From: Fiona Pudge <Fiona.Pudge@sportengland.org>
Sent: 25 June 2020 11:00
To: Planning
Subject: App Ref: 3/2020/0315 - The Rhyddings Langho BB6 8AF - Sport England Ref: PA/20/NW/RV/55804
Attachments: policy-exception-5.pdf

The application proposes a change of surface from natural turf to artificial and the proposal must meet paragraph 97(c) of the NPPF and Exception E5 of Sport England's Playing Fields Policy. Please could the following information be provided as soon as possible:

Proposed Site Plan - 1:1000

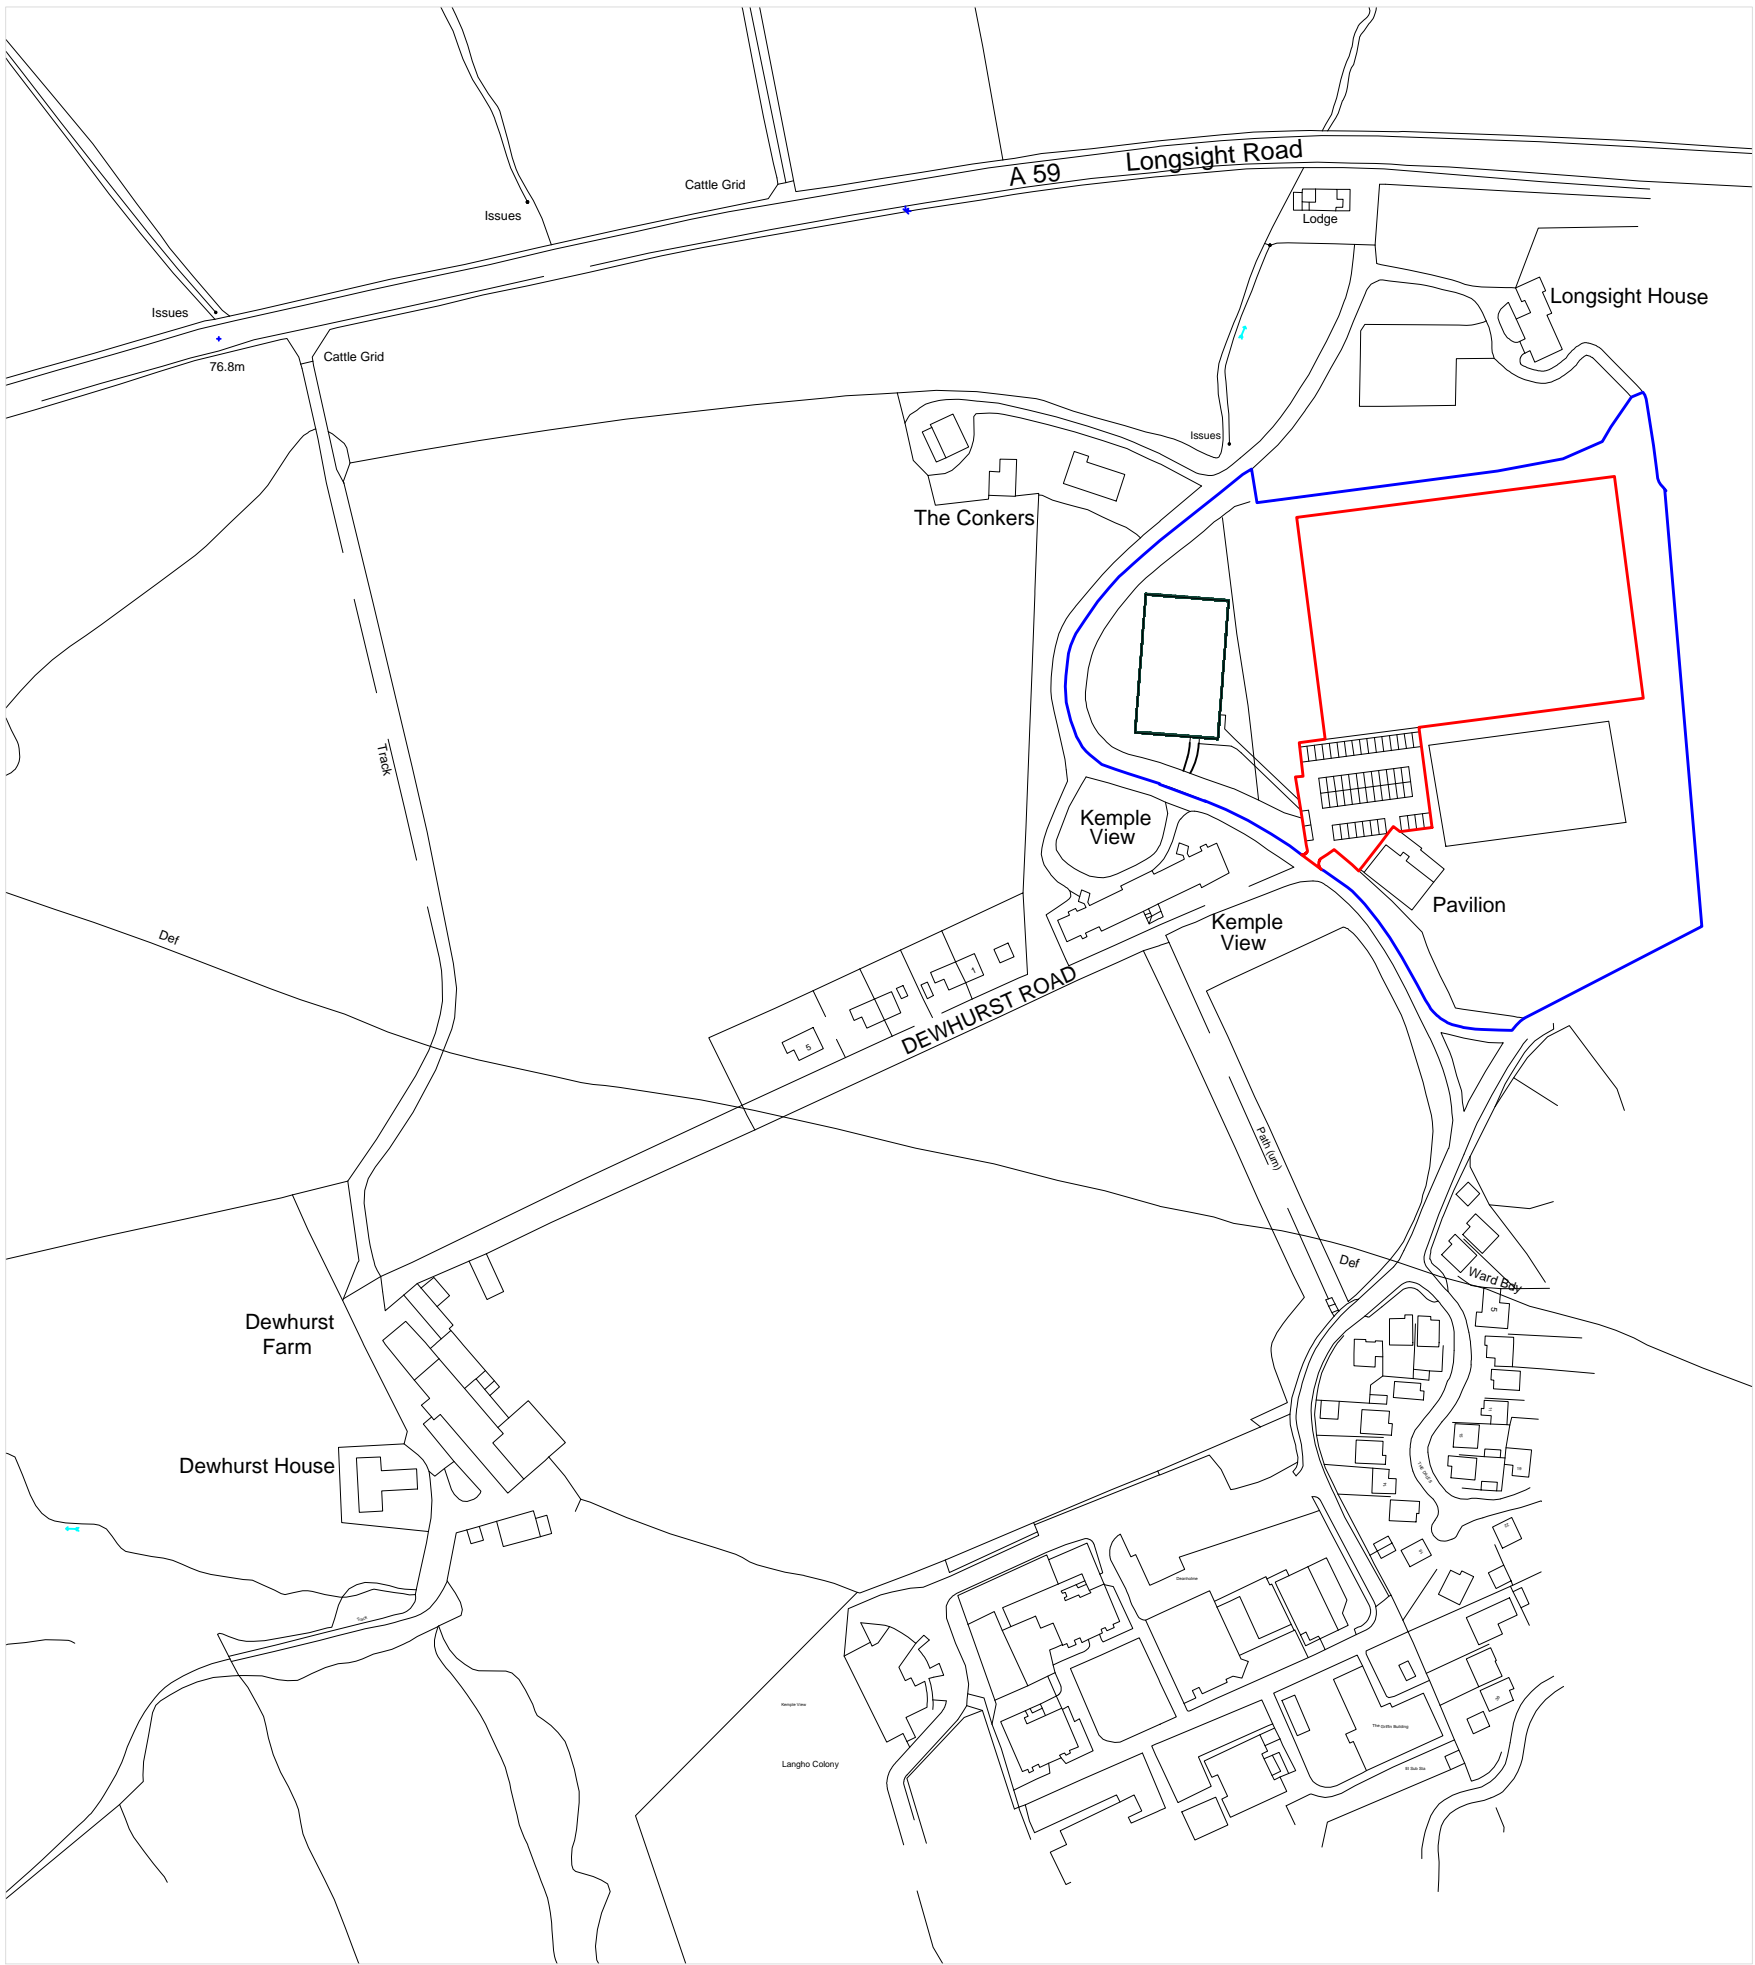
4. The Football Foundation can confirm the proposed floodlighting plan and specification are acceptable. In respect of the 3G, there is limited/no supporting technical information and therefore the Football Foundation would seek clarity/supplementary information to evidence the proposed pitch will meet the requirements of The FA Guide to Football Turf Pitch Design Principles and Layouts. More specifically, we would highlight the following key points:

General – 3G AGP designs appear to be in line with FA recommendations but should be checked against The FA Guide to Football Turf Pitch Design Principles and Layouts.

Line marking – We recommend that over-marking are made to allow different formats of football (e.g. 5v5, 7v7, 9v9 and 11v11). Over-marking should adhere to The FA Guide to Football Turf Pitch Design Principles and Layouts.

Recessed fencing – We recommend that the fencing is recessed to allow for safe and easy goal storage.

Fence height – The FA recommend the fence height on all sides of the 3G AGP is 4.5m.

Run-off – A minimum safety run off 3m should be provided.
